M3 Junction 9 Improvement

Scheme Number: TR010055

8.6 Applicant Response to Written Summaries of Oral Submissions at Open Floor Hearing 1 (OFH1)

~~15 June 2023~~ 17 July 2023

DRAWING TITLE  
 FIGURE 2.6 - THE SCHEME: TEMPORARY DIVERSION OF WALKING, CYCLING, AND HORSE RIDING ROUTES APFP REGULATIONS 5(2)(a) DOCUMENT REFERENCE 6.2

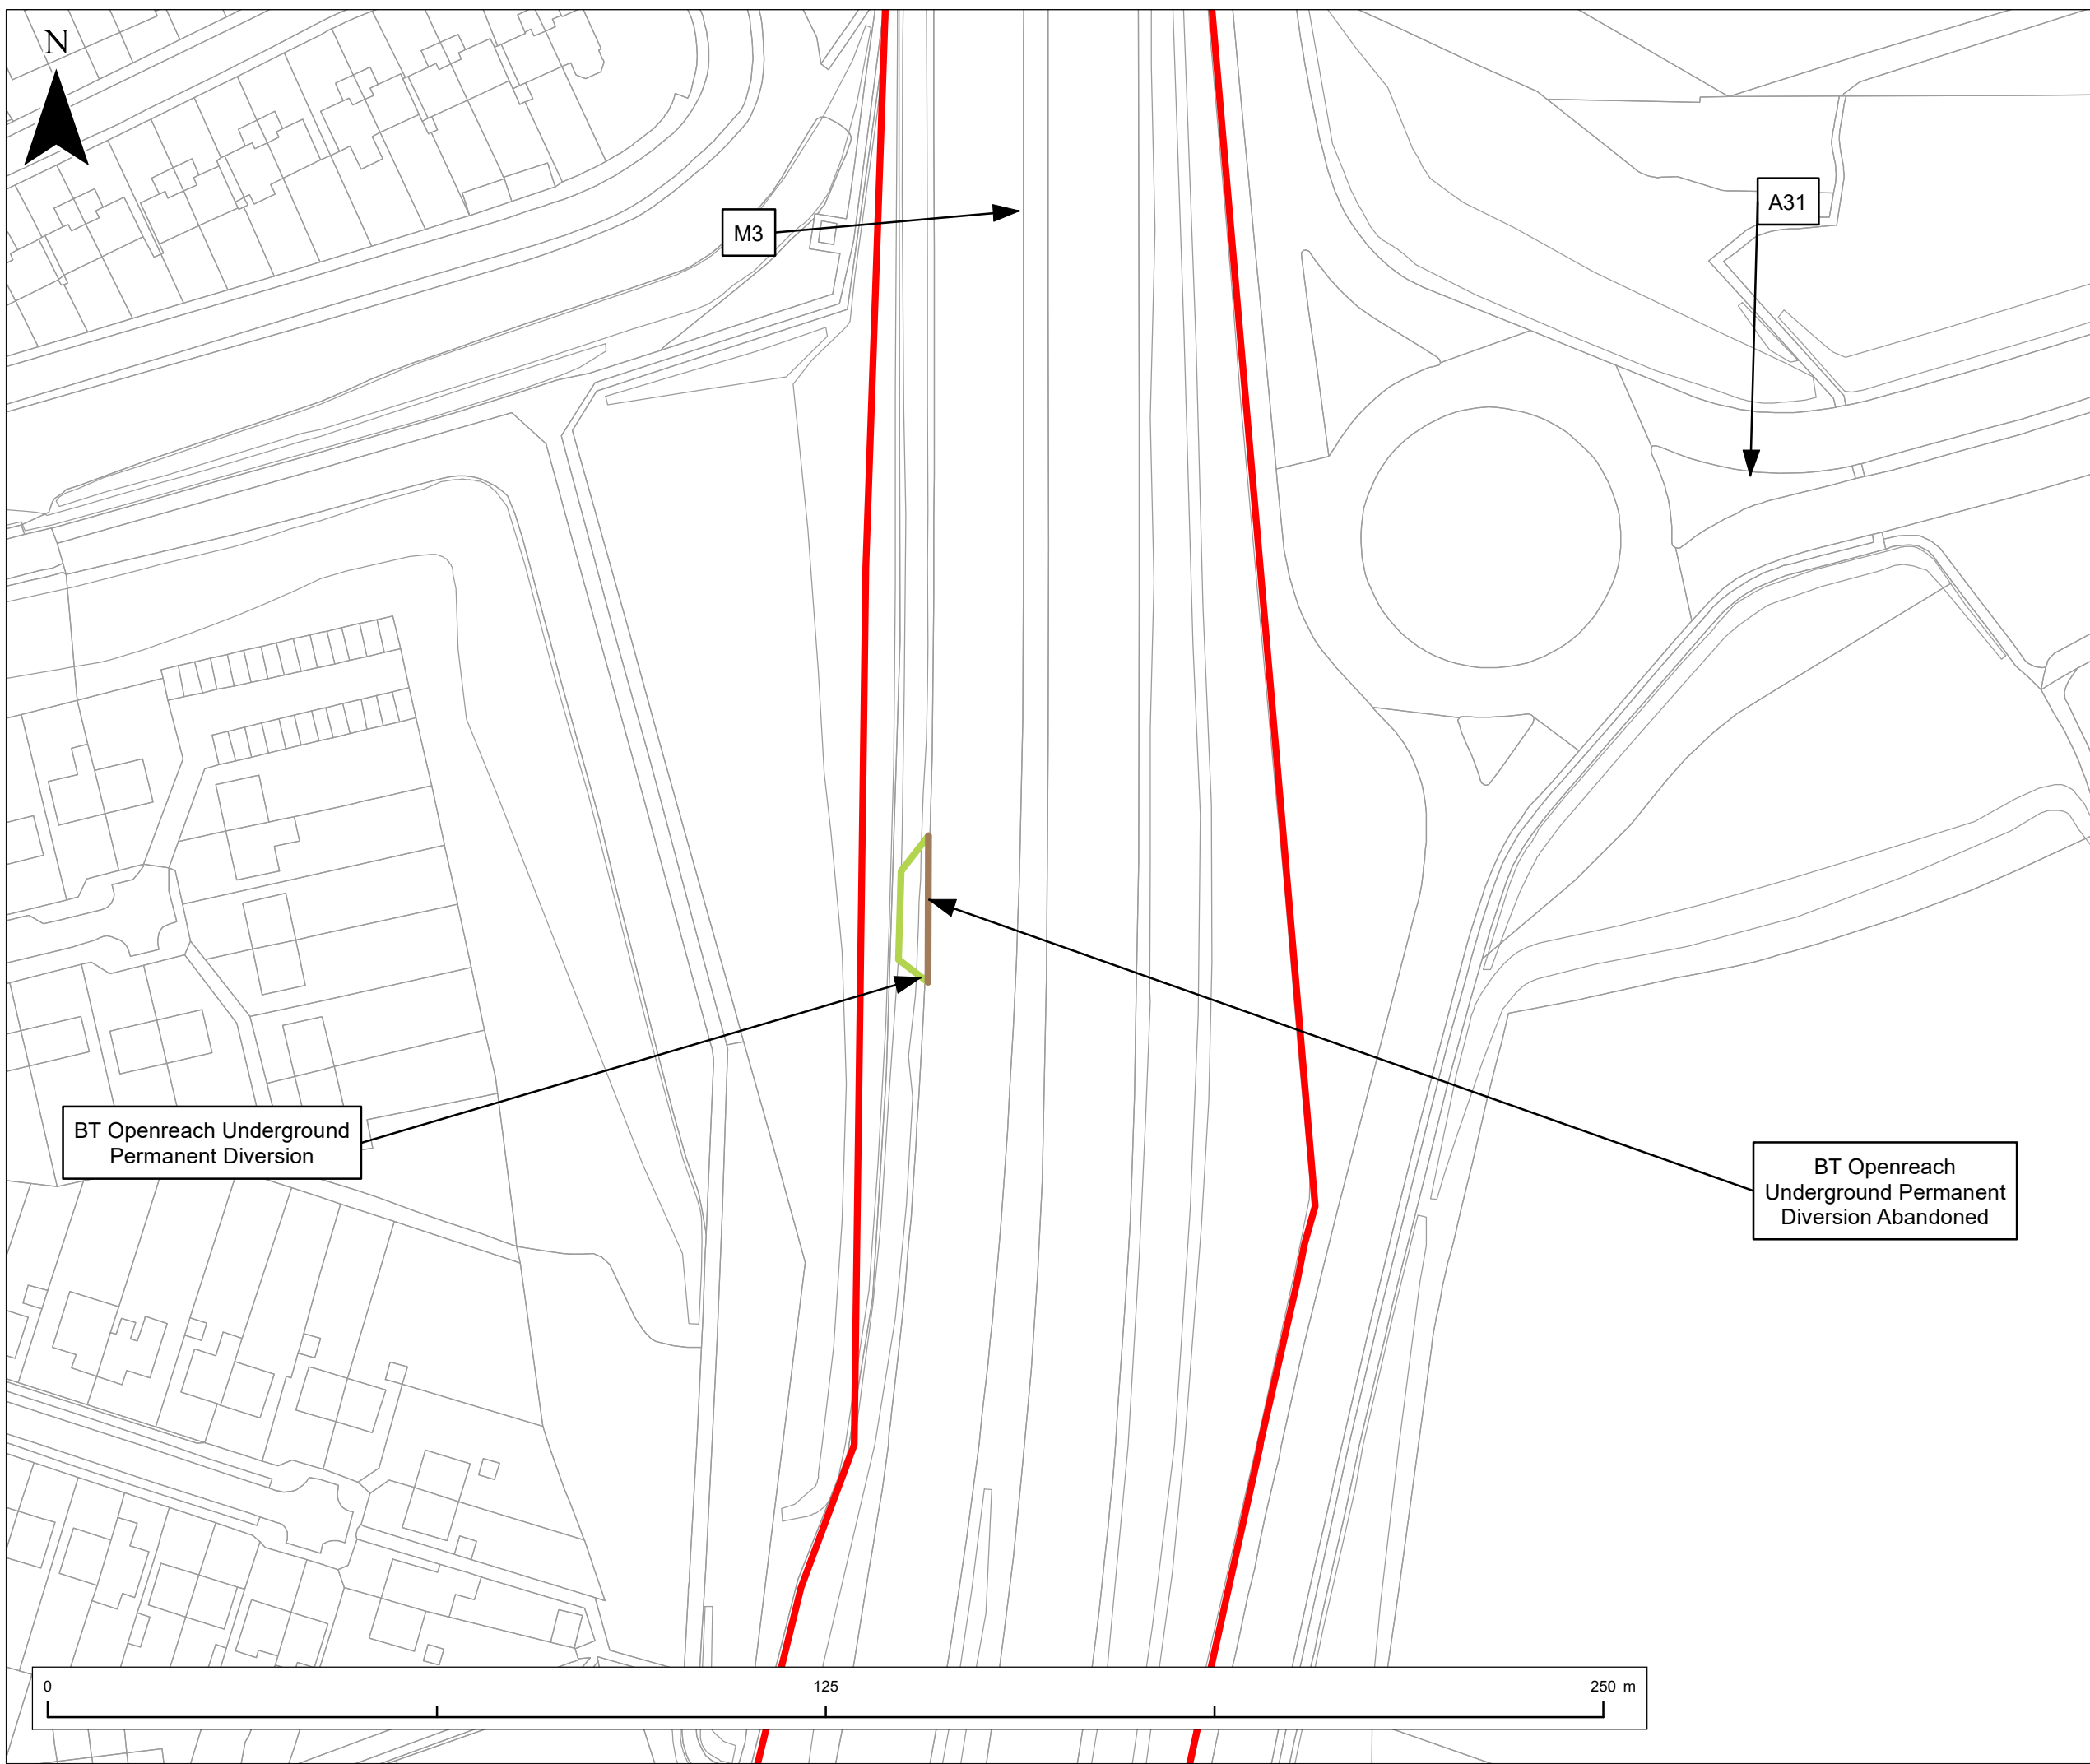
Summary of Oral Representation	Applicant's Response
<p>amount of surface run-off cannot be fully understood.</p> <p>[Extract from General Arrangement Plans provided in REP1-035]</p> <p>The borehole and the infiltration basin are situated at a low point in the landscape and we are concerned that our drinking water supply will become contaminated. The costs and disruption of a new borehole sited away from the basin, or the installation of mains water and future water costs would be considerable.</p> <p>I am concerned about Long Walk being used for access by works traffic. [REDACTED] are accessed only via Long Walk, a narrow lane which includes a bridge beneath the M3. The resident [REDACTED] is very concerned about the impact the works will have on her property. Several PRow converge near Fulling Mill (Itchen Valley Footpaths 20, 21, 22, 49, 52 and Restricted Byeway 19) and during works access will be restricted. Several of these paths are currently in need of maintenance. Once the new bridleway opens these paths should see increased use and will need to be improved and maintained accordingly.</p>	<p>With regards to light pollution, Chapter 7 (Landscape and Visual) of the Environmental Statement (ES) (6.1, Rev 1) considers the effects of light pollution during both construction and operation of the Scheme. As stated in the first iteration Environmental Management Plan (fiEMP) (7.3, Rev 2): <i>'There will be static lighting points fixed to temporary structures such as the masts, cabins, workshops, gantry cranes and silos with the lamps up to 10m in height. These will be used to illuminate regularly used work areas, the car park and access areas. Baffles will be installed on all lighting columns and light is to be angled to face works.'</i></p> <p>It is the Applicant's understanding that the borehole detailed as Mansard House is the location referred to by Ms Rosewell, near to the Shoulder of Mutton Farm off Easton Lane. This borehole for private groundwater abstraction is shown on Figure 3.14 'Licenced and private abstractions and SPZs' of Appendix 13.2: Hydrogeological Risk Assessment (6.3, APP-144) and is 90m east of the Application Boundary. The borehole is up the hydraulic gradient of the proposed works which means that groundwater flowing past Drainage Basin 5 will be flowing away from the borehole. It is therefore considered to have a negligible risk of impacting it.</p> <p>Walking, cycling and horse-riding route closures and associated diversions would be avoided unless absolutely necessary. However, due to the nature of the work required on the M3 Junction 9 gyratory, there would be a diversion required to the National Cycle Network (NCN) Route 23 as the new gyratory abutments are constructed. Please refer to Figure 2.6 (Temporary diversion of walking, cycling and horse-riding routes) of Chapter 2 (The Scheme and its Surroundings – Figures (Part 3 of 4)) of the ES (6.2, APP-063) which shows two temporary diversion routes for NCN 23.</p>
